County of Bernalillo
State of New Mexico
Public Works Division
Transportation Planning Department
415 Silver Ave SW Albuquerque, NM 87102

Subject: Coyote Gravel Inc. Secondary Site DRAFT Traffic Impact Study

Below are Bernalillo County comments on the subject preliminary traffic impact analysis screening dated November 27, 2024. Please address these comments for the subsequent submittal.

SITE PLAN

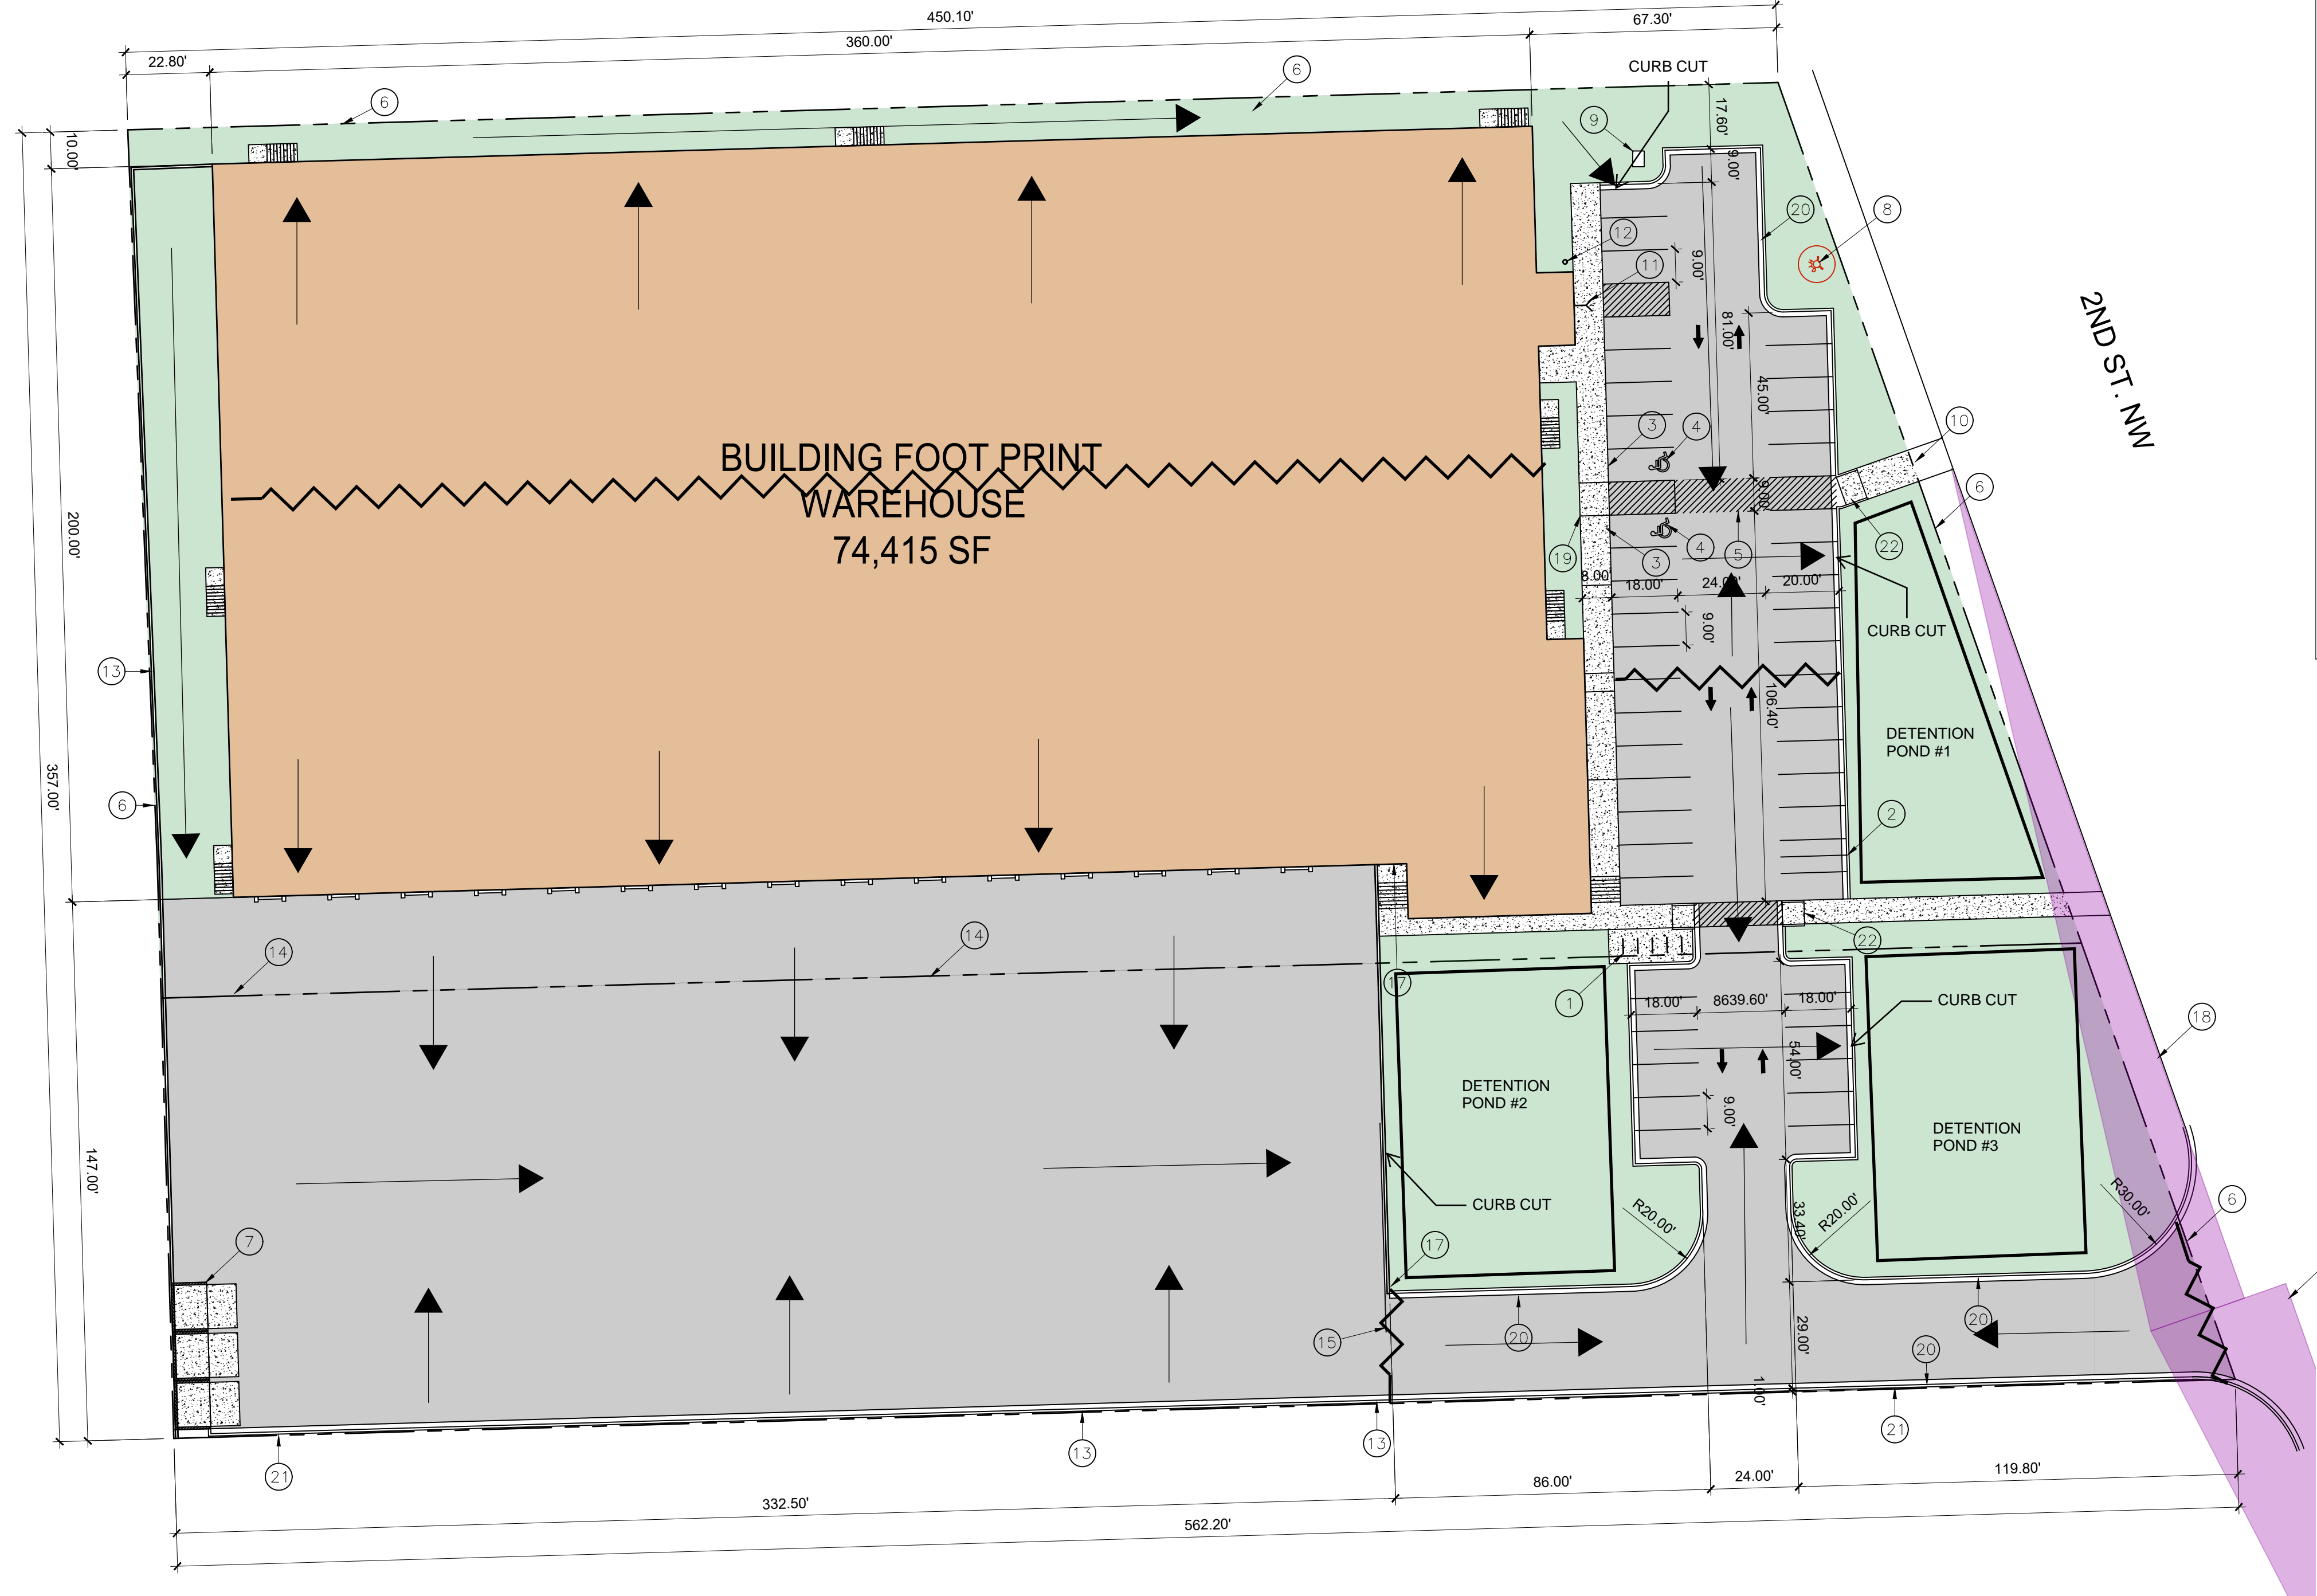
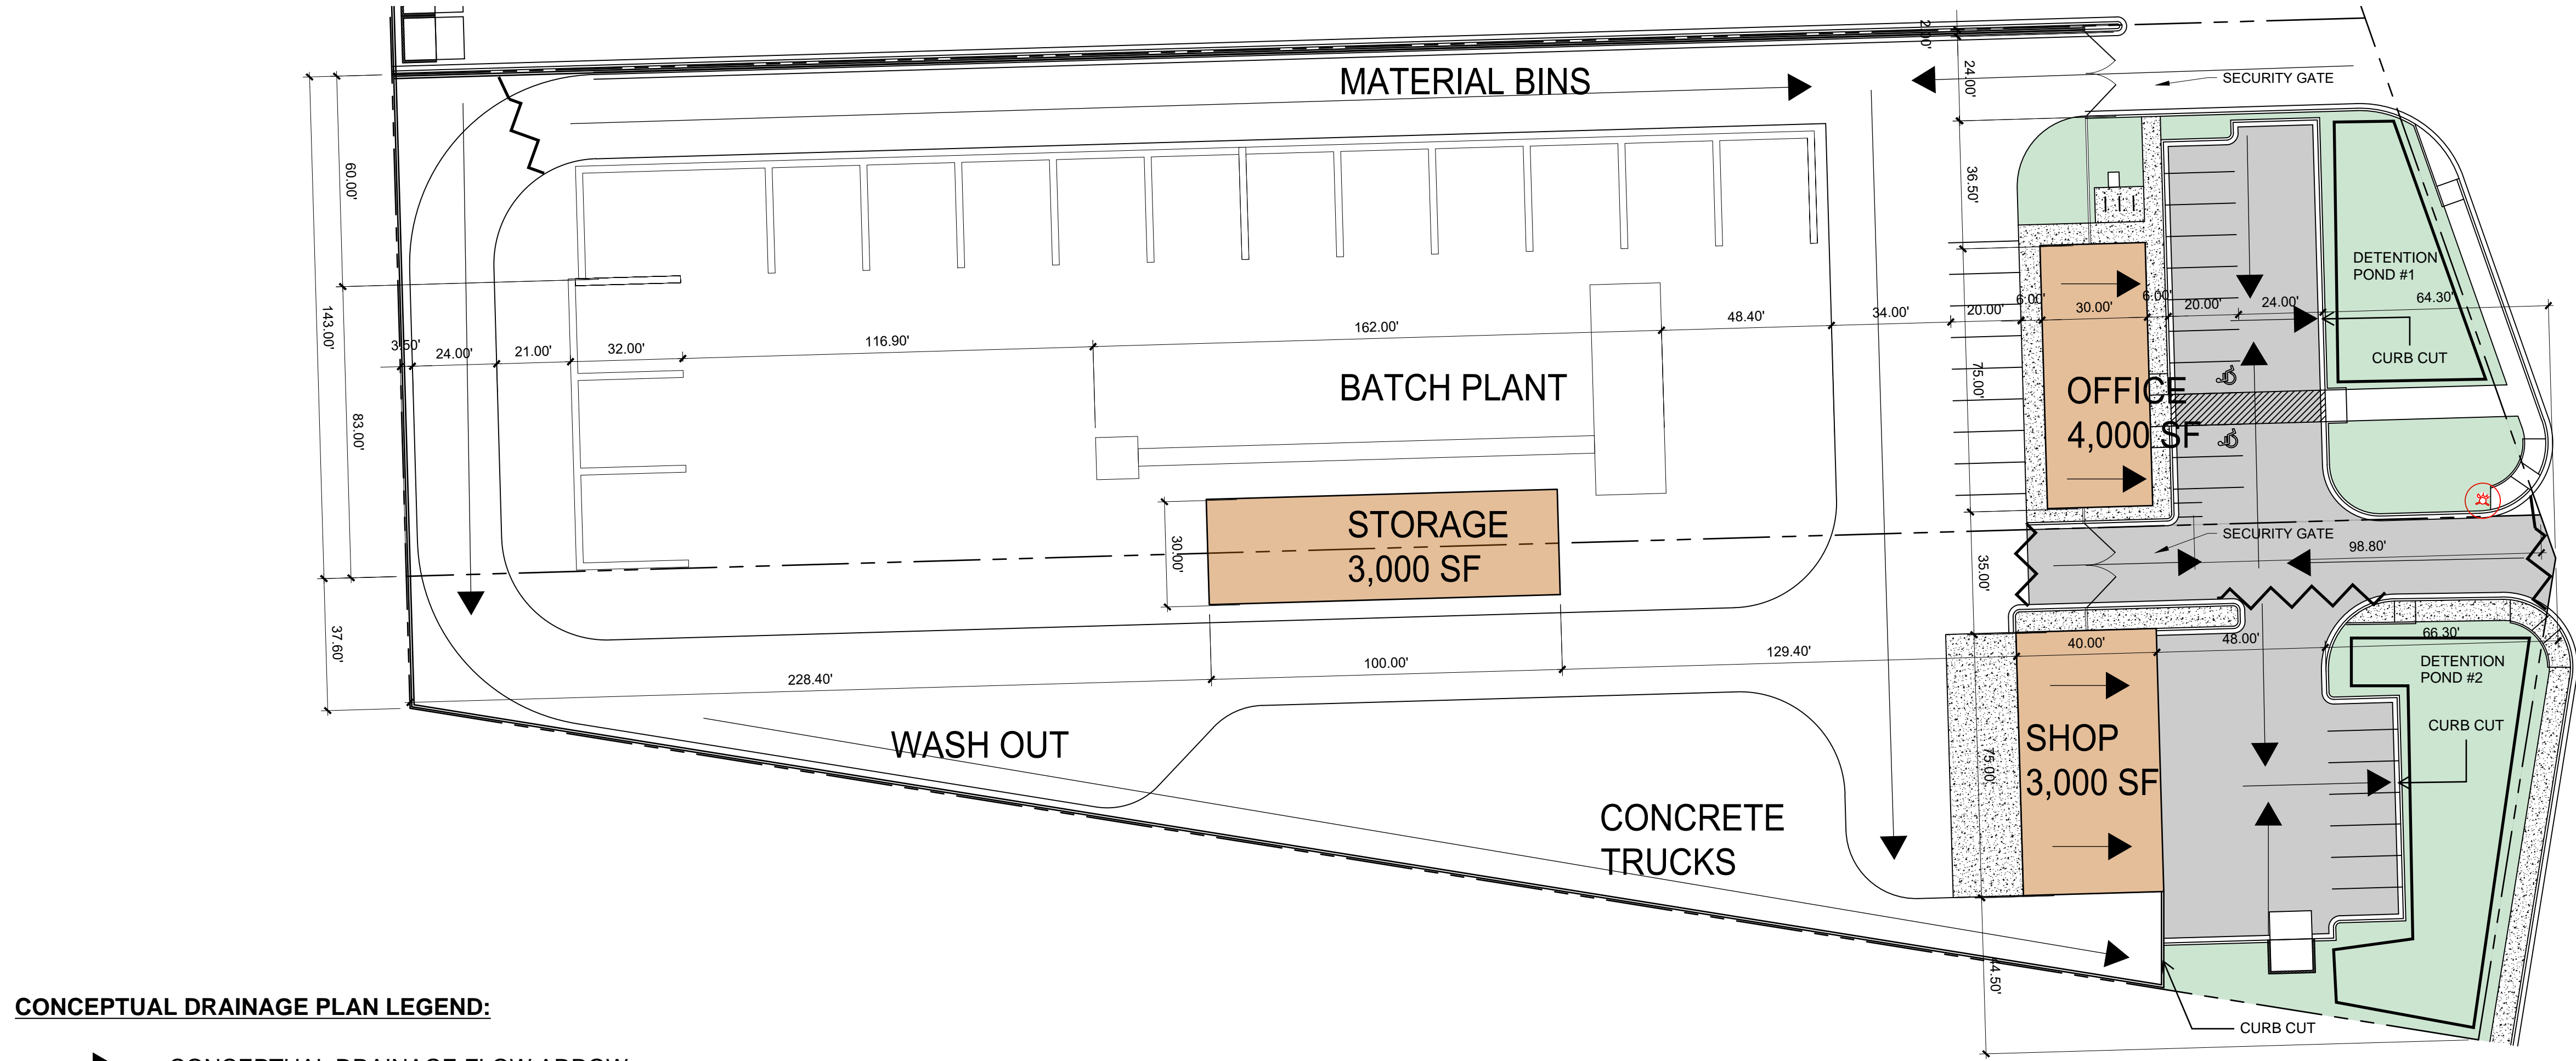
1. Same comments as COA concerning site plan. Please note that any internal site circulation cannot rely on 2nd St. Ensure that the two sites are connected for any reason someone needs to visit both the warehouse to the north and the office/shop to the south.
